RE: New High School in Jerrabomberra SSD RFI

Reference is made to the response submissions from the Department of Planning, Industry and Environment (DPIE), - Queanbeyan-Palerang Regional Council and Transport for NSW (TfNSW) with respect to State Significant Development Application (SSDA) submission for the New High School in Jerrabomberra (Reference SSD – 24461956).

Table 1 DPIE RtS Letter

Project
 High School in Jerrabomberra
 ENVIRONA DRIVE,
 JERRABOMBERRA NSW 2619
 Drawing Title
 STORMWATER DRAINAGE
 PLAN - SHEET 1

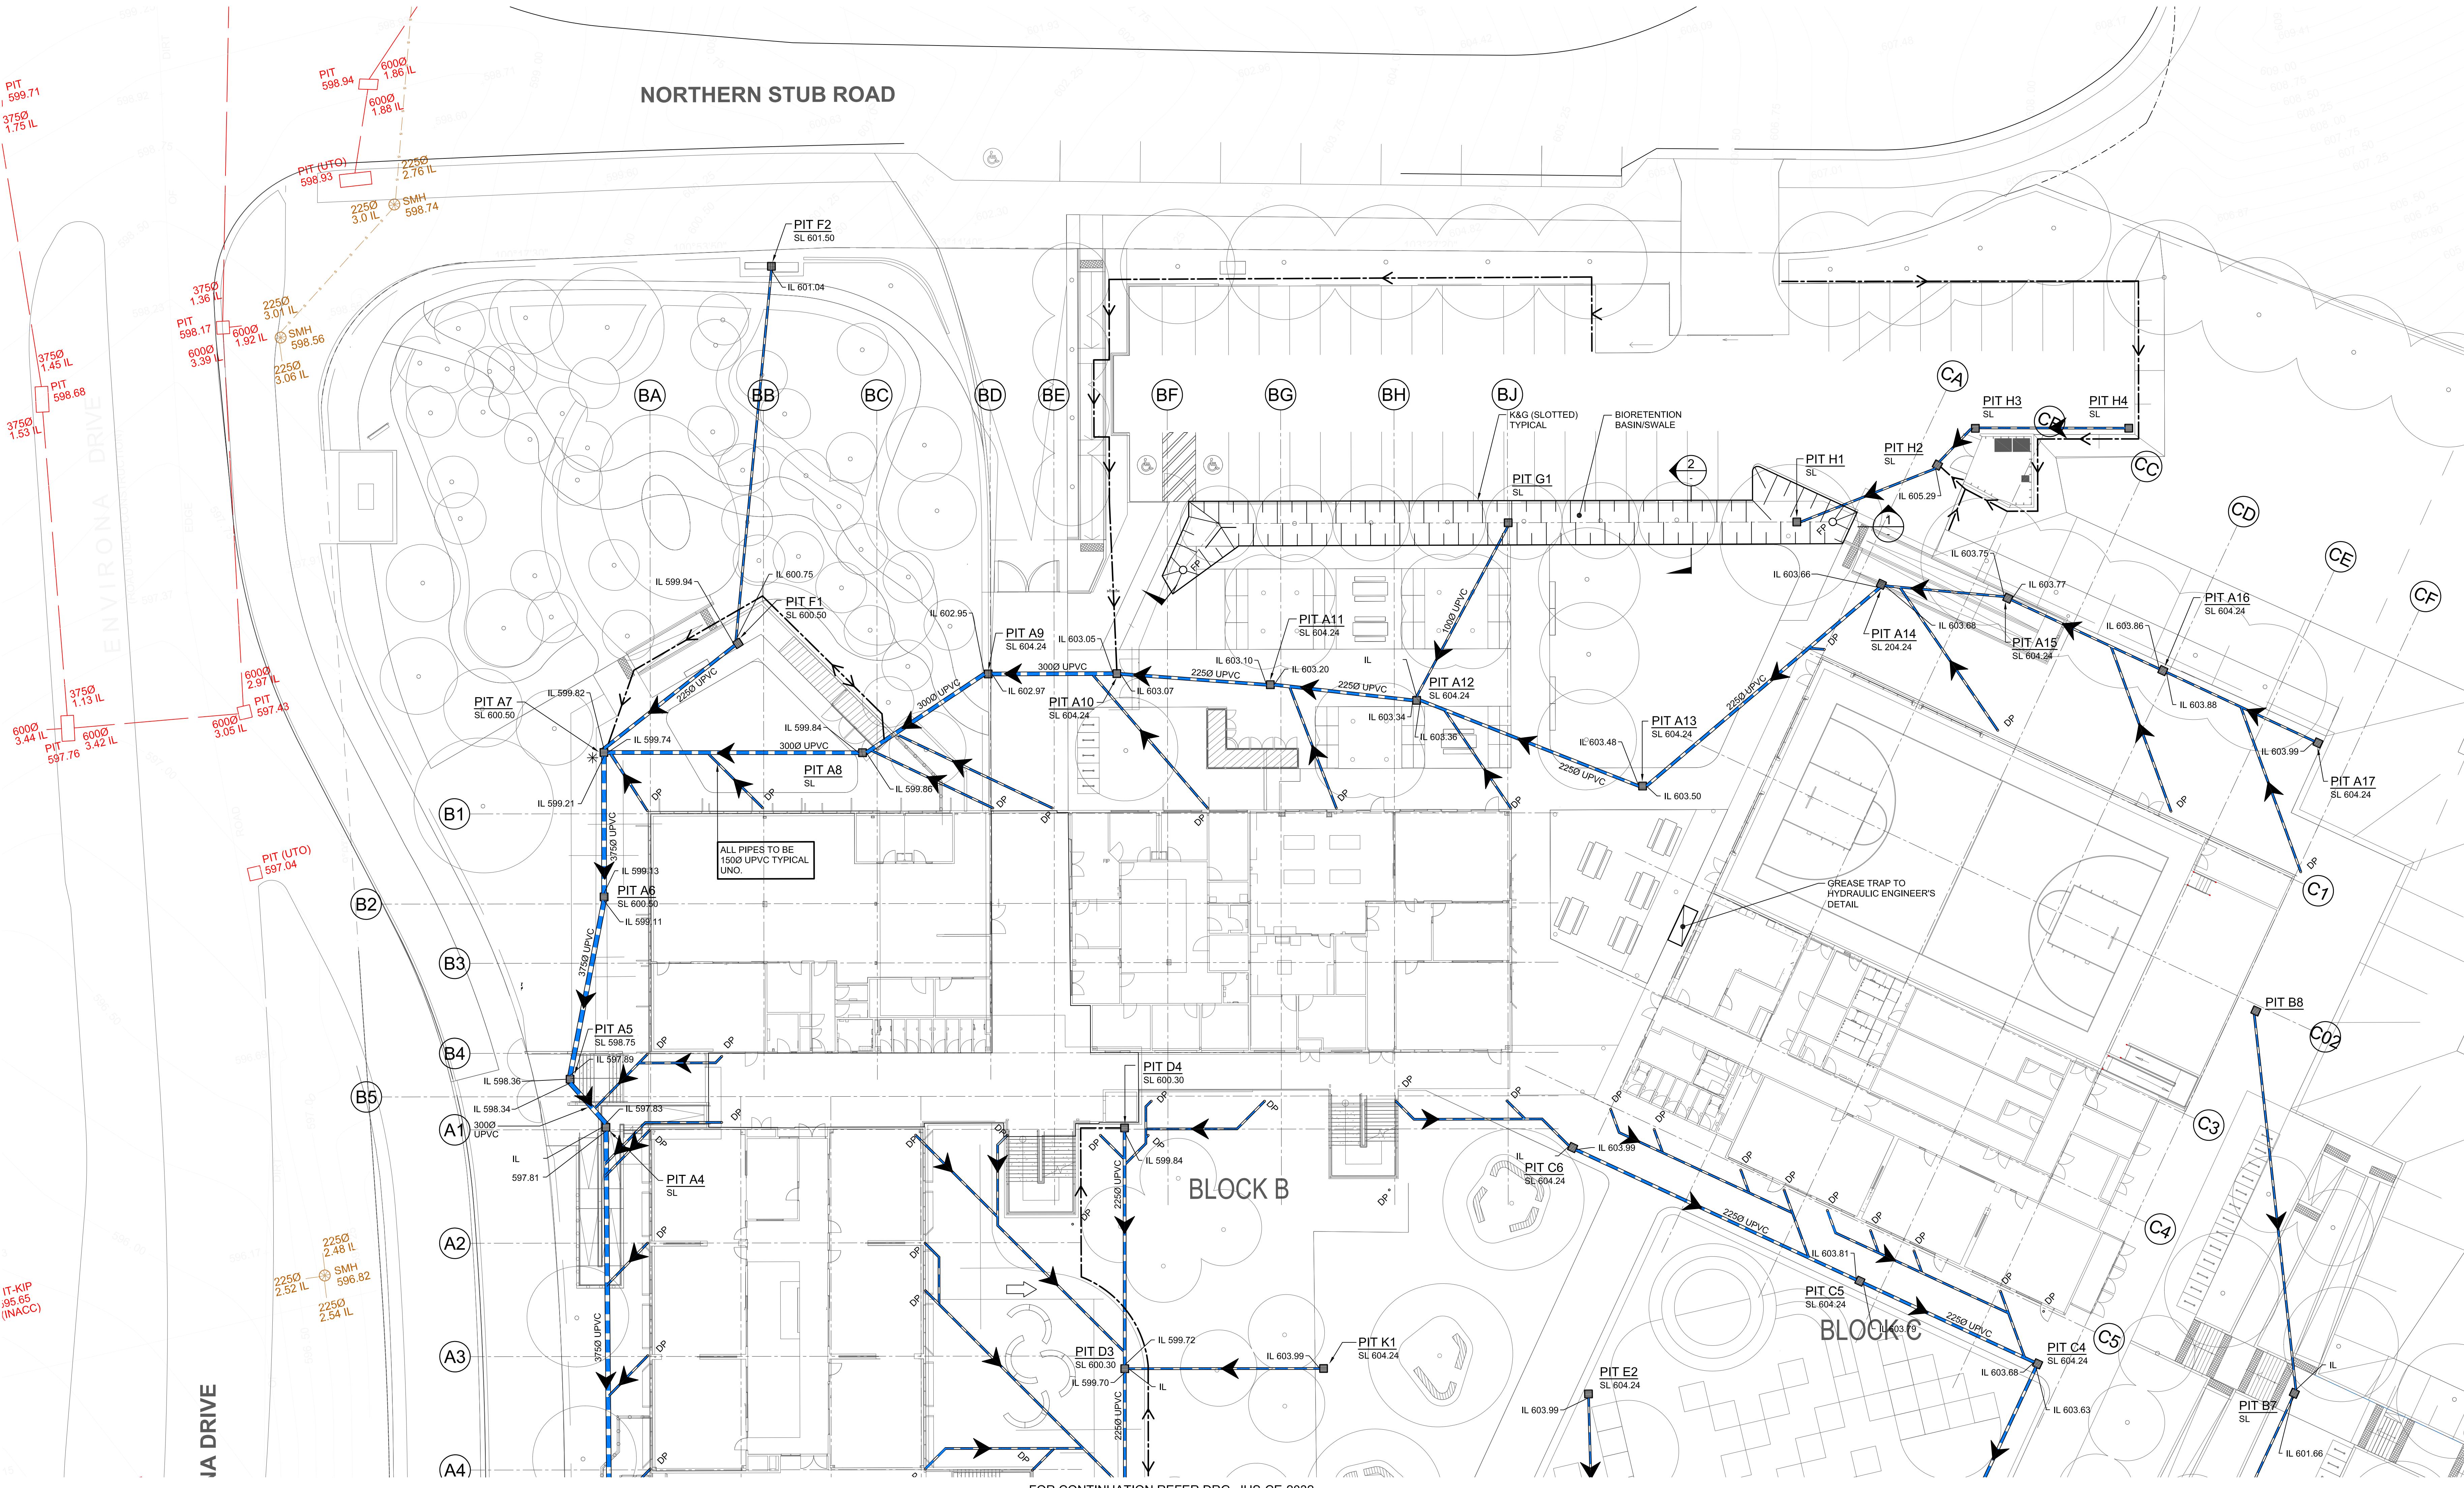
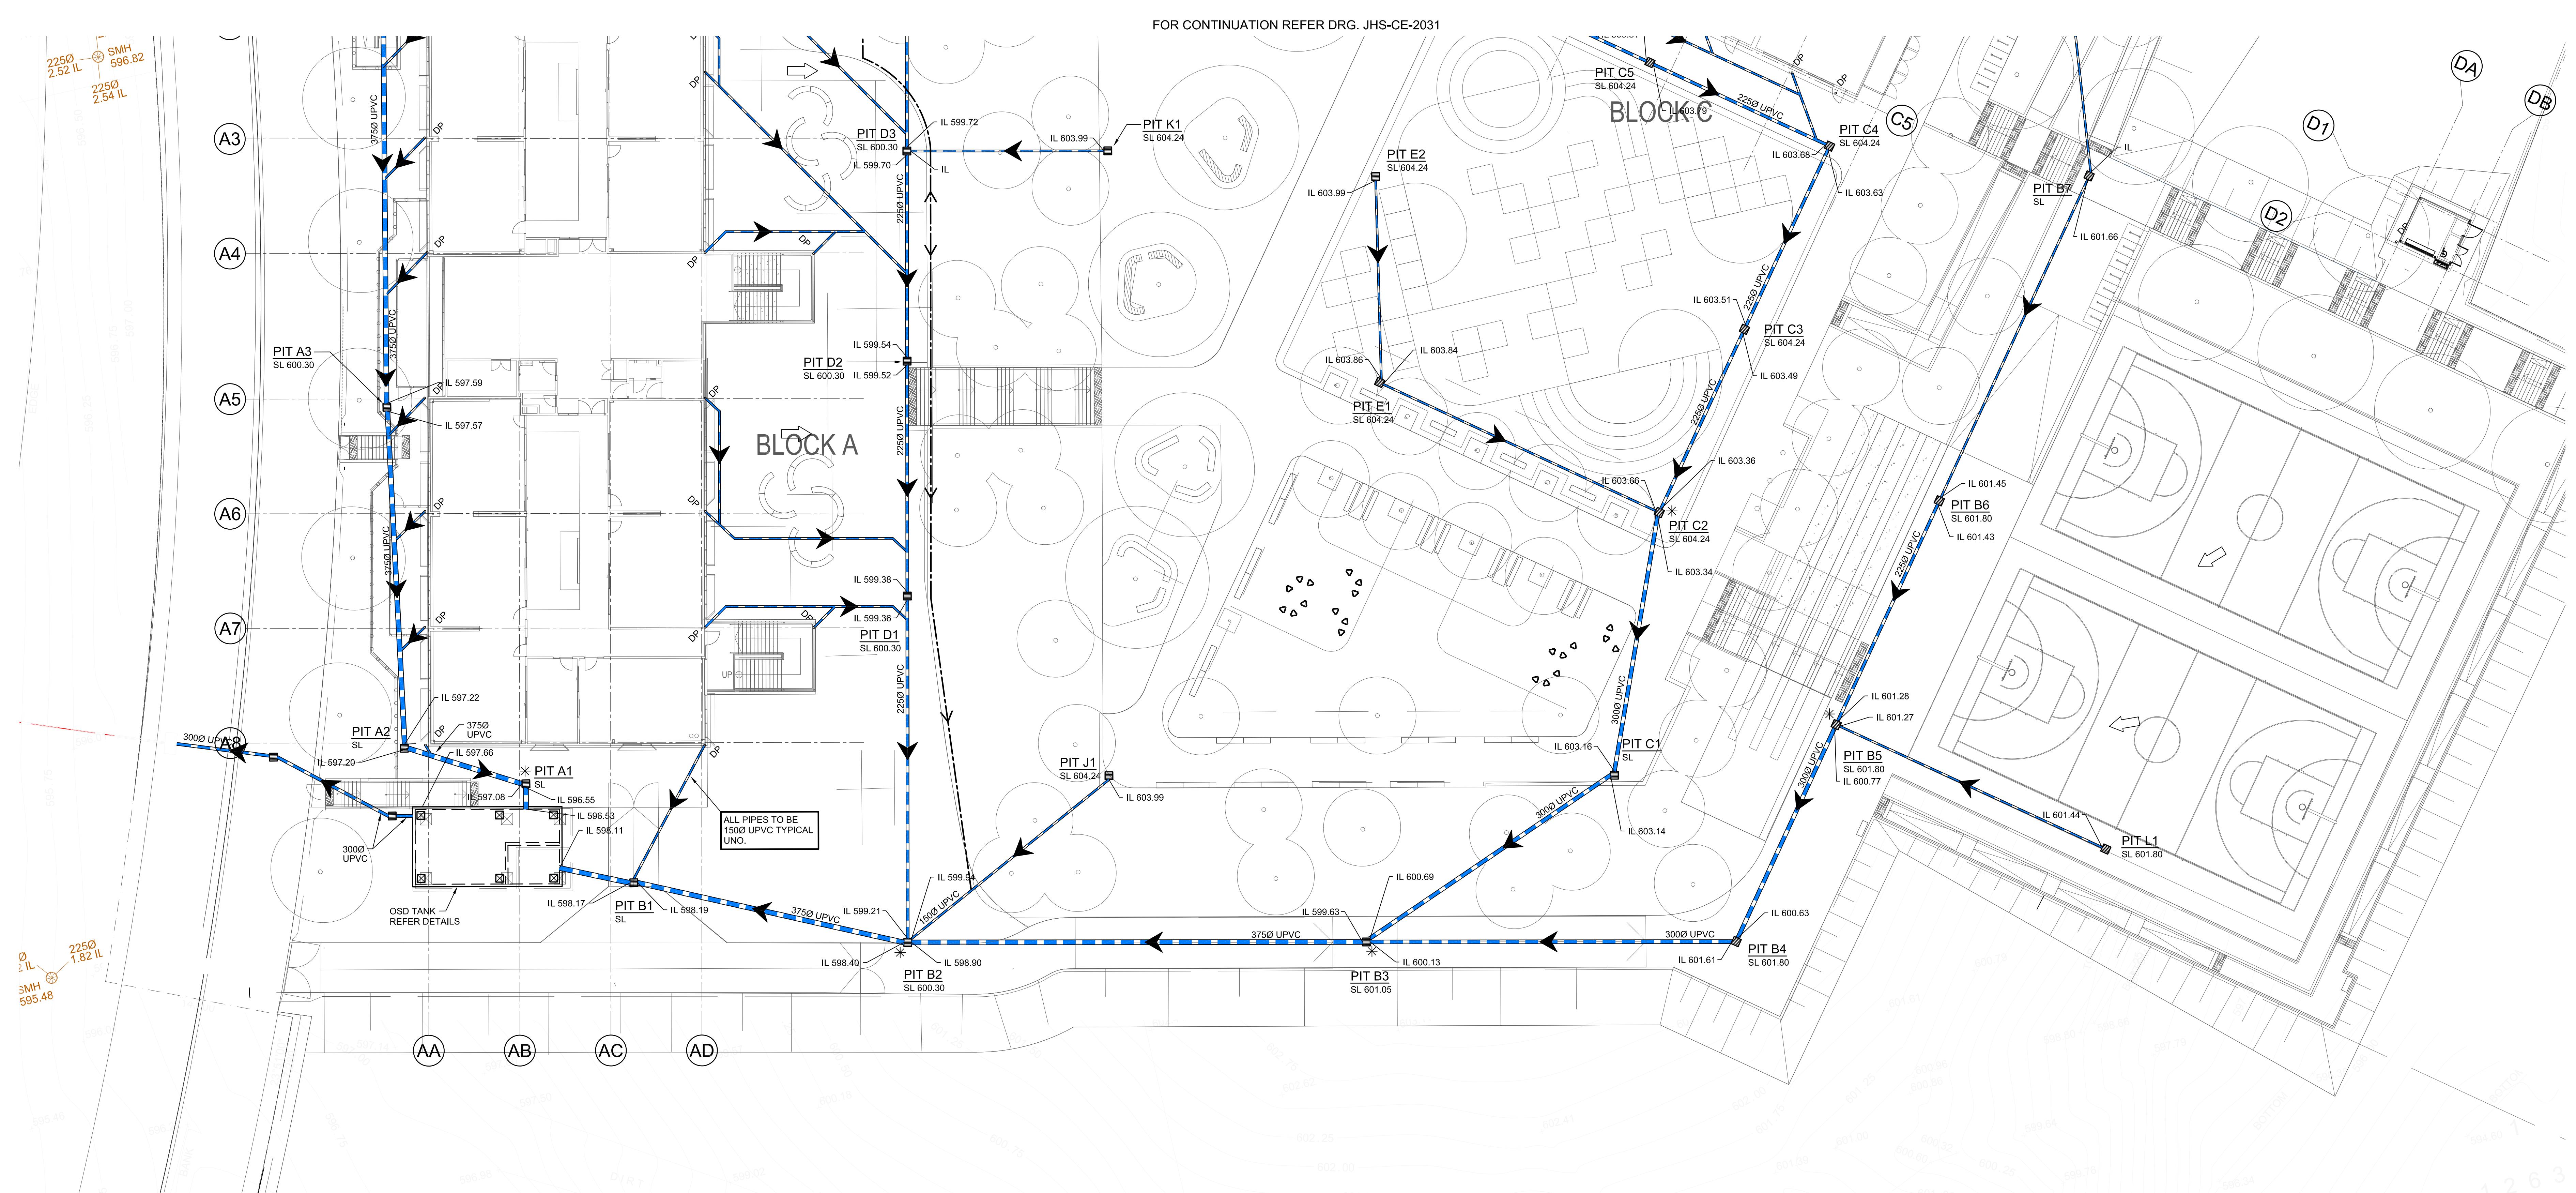
The design of the pick-up and drop-off, which is dependent on a maximum active transport take-up, is described as using the north road off Environa Drive for vehicles to queue to use the facility. The north road isn't wide enough to support queued vehicles for the pick-up and drop-off and traffic that is driving through the north road to access the car-park such as teachers and emergency vehicles. The operation of the pick-up and drop off stacking and queueing on a public road that will then restrict access of traffic in a travel lane is not a safe design. This is particularly a concern for emergency/ambulance vehicles that are meant to have safe through access to their designated access point. This design is also a concern for the afternoon 'pick-up' function where parents arrive (often up to 30 minutes prior to school finishing) and have no-where to stack and wait (or park) that will not impact the travel lane on the north road and afternoon pick up risks waiting vehicles stacking onto Environa Drive.

The Traffic assessment describes the pick-up and drop-off area as a 'designated facility' – it is unclear if this will be indented but it is recommended. Although if this occurs it will need to consider location of existing services such as stormwater pits which may

<p>need to be modified or relocated.</p> <p>Council does not believe the 7 designated spaces of the pick-up and drop off will be sufficient for the capacity.</p> <p>It is uncertain if the proposed mobility parking spot in the pick-up and drop off facility can meet the required mobility parking standard. It should be noted that the north road has a grade of 8% and would not be suitable for a disabled parking space. AS2890.5-1993 requires the fall for a disabled parking space to be no greater than 1:33 in any direction.</p> <p>Recommendation - That the applicant carry out a further review of the drop off/pick up zone to identify the potential impacts of queuing in the north road cul-de-sac and whether additional spaces can be provided. (Objection)</p>	<p>order of 10 – 30 seconds in most instances. Accordingly, the kiss and drop facilities are expected to be able to accommodate significantly more than 105 vehicles in peak periods.</p> <p>The analysis performed indicates that seven kiss and drop spaces plus the available additional queuing space for 38 vehicles are considered sufficient to accommodate the expected demand and avoid the risk of queuing vehicles on Environa Drive, thereby not affecting the through travel movement of vehicles (including emergency services).</p> <p>Furthermore, during the initial phase of school operations, there will be traffic management in place to educate parents to establish appropriate behaviours.</p> <p>At approximately 8.5 m wide, the north/stub road is sufficiently wide enough to support queued vehicles for the pick-up and drop-off and traffic that is driving through the north/stub road to access the car-park such as teachers and emergency vehicles.</p> <p>3. Risks if transport targets not achieved</p> <p>With respect to the mode share analysis outlined in Item 1 above, a number of scenarios were developed in the Transport Assessment, as follows:</p> <ul style="list-style-type: none"> • A base case, in accordance with current mode share data for regional schools. • A reach scenario, using depersonalised household data, based on the maximum number of students who could walk, cycle or catch the bus to school. • A target scenario, which is identified as being between the base and reach mode shares. <p>The target scenario assumes that transport planning measures will be implemented to encourage sustainable modes. The targets in the Transport Assessment were presented to all the key stakeholders in Transport Working Group meetings held on 9 September 2021.</p> <p>For the base scenario, it was assumed that up to 45% (225 students) will be picked up/dropped off. Assuming an occupancy rate of 1.4 students per vehicle, this corresponds to 160 vehicles in the peak 15 minutes periods of activity.</p> <p>As detailed in Item 3 immediately above, based on conservative</p>

Prior to accessing the seven kiss and drop bays, vehicles are required to traverse the northern side of the stub road and the turning head, a distance of approximately 185 m. Assuming six metres per vehicle (accounting for the gaps between vehicles), this area can accommodate approximately 30 additional vehicles. Additionally, there is a distance between the kiss and drop zone and Environa Drive of approximately 50 m which could accommodate approximately eight additional vehicles (45 total).

Assuming that the school peak will occur over a 15-minute period and conservatively it takes approximately 60 seconds for a student to embark or disembark a vehicle, each space would turn over approximately 15 times. Therefore, the seven spaces will accommodate at least 105 vehicles in the peak 15 minutes of school activity.

assumptions, the seven dedicated kiss and drop spaces will have a 15 minute capacity of at least 105 spaces. It is noted:

- In addition to the seven kiss and drop bays, the stub road can accommodate up to 38 additional vehicles (45 total). Accordingly, any additional demand can be accommodated.
- Transport planning measures to encourage sustainable modes of transport will be implemented at the high school.
